22 OCT 2012

INTEGRA OPEN CUT AND UNDERGROUND COAL PROJECTS – 75W MODIFICATION (08_0101 Mod 2 and 08_0102 Mod 2)

KAREN MARLER
Head Regional Operations Unit – Hunter
Environment Protection Authority

Figure 1 - Conveyor transport only, Leq (15-min), dB(A) inversion meteorological conditions

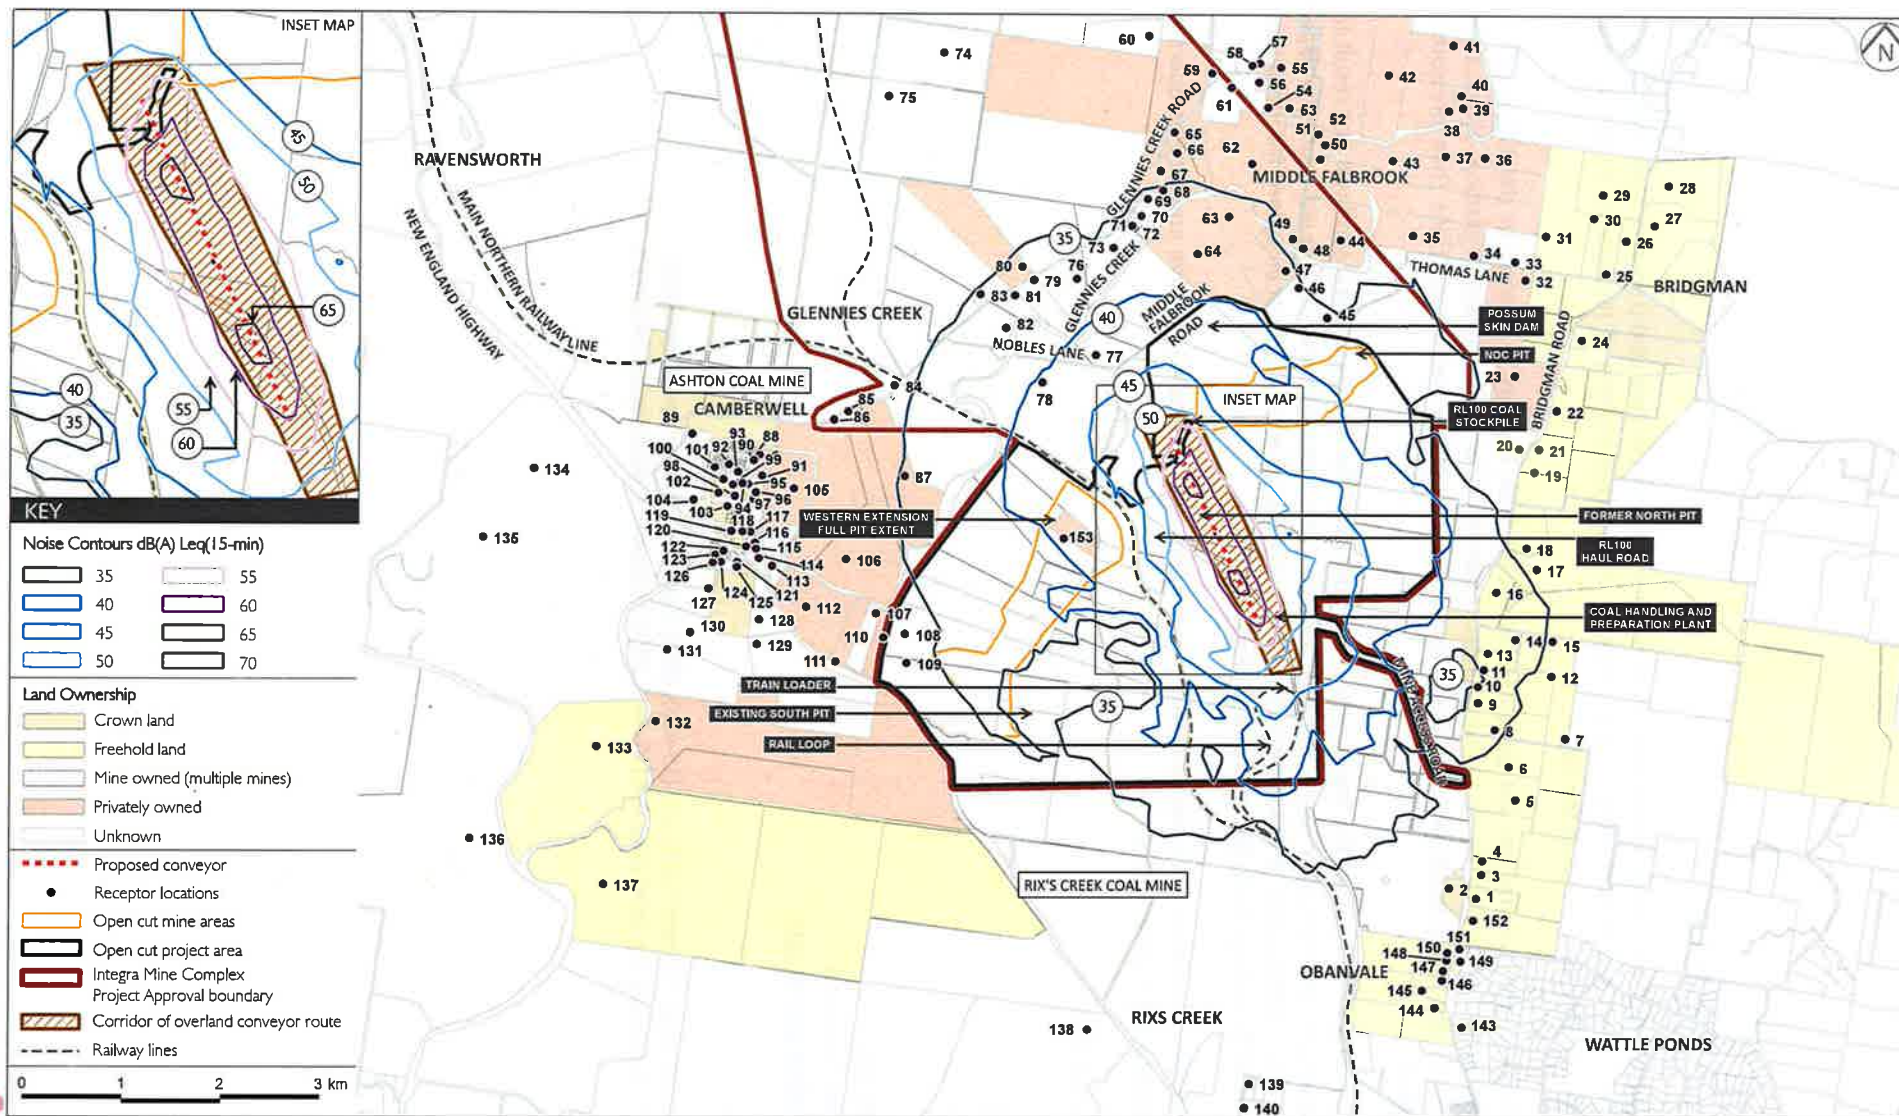
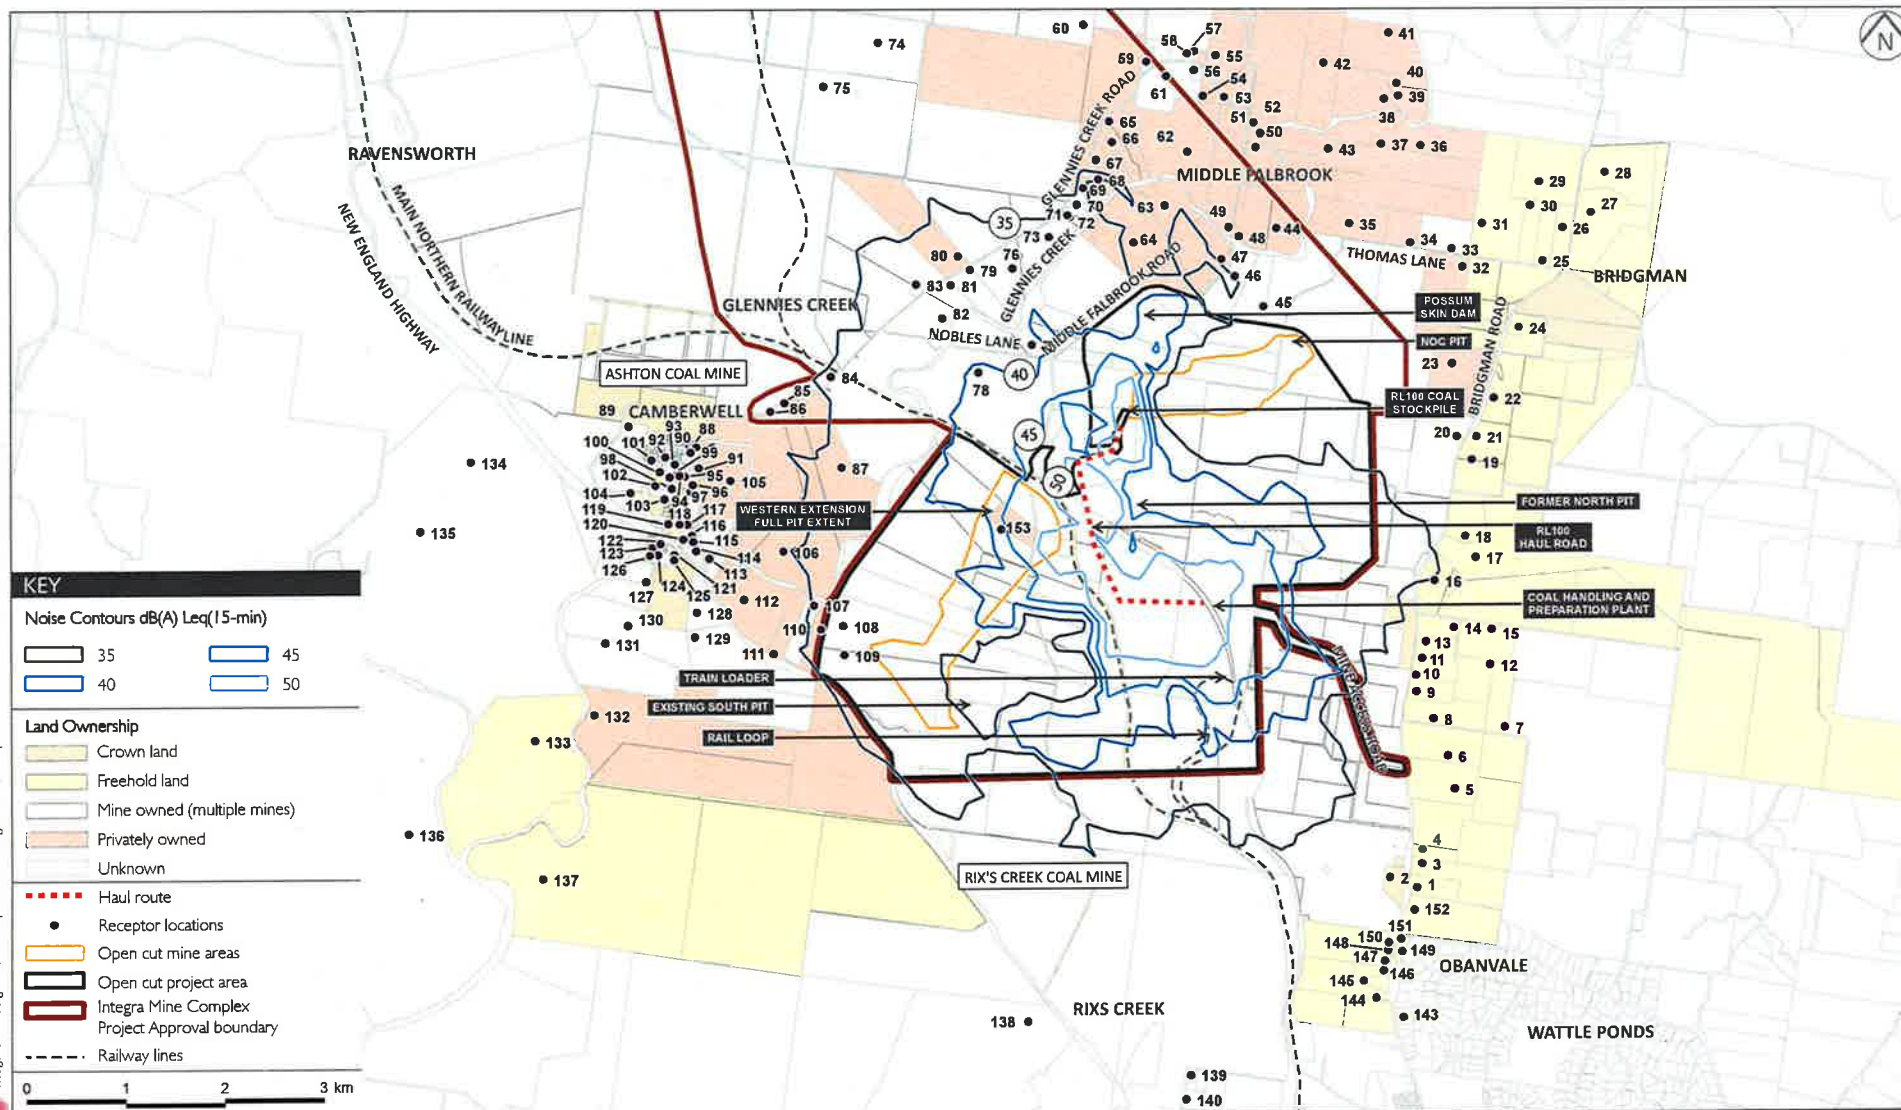
The EA includes in Appendix C the modelling results which compare the noise levels of the conveyor option against the haul truck option. There is little detail in the EA on the modelling methodology and it appears that the 'criteria' listed in the Tables in Appendix C are not the same as the noise limits in the Project Approval. This makes it difficult to assess compliance or otherwise with the noise limits if haulage by trucks was maintained over constructing the conveyor.

It appears from the noise levels in Appendix C that some properties will be worse off by continued haulage by trucks compared with the conveyor, however the discussion in Appendix C indicates that modelling did not include the 3 metre bund which the EA states has now been constructed. As predicted noise levels are not provided for operations with and without the bund, it is not clear what benefit the 3 metre bund will have for those receivers who may have benefited from the conveyor. EPA considers that the onus is on the proponent to achieve the noise limits in the existing Project Approval (and Environment Protection Licence (EPL)).

The EPA can support the proposal provided that there are no changes to the noise limits in the EPL and current Project Approval.
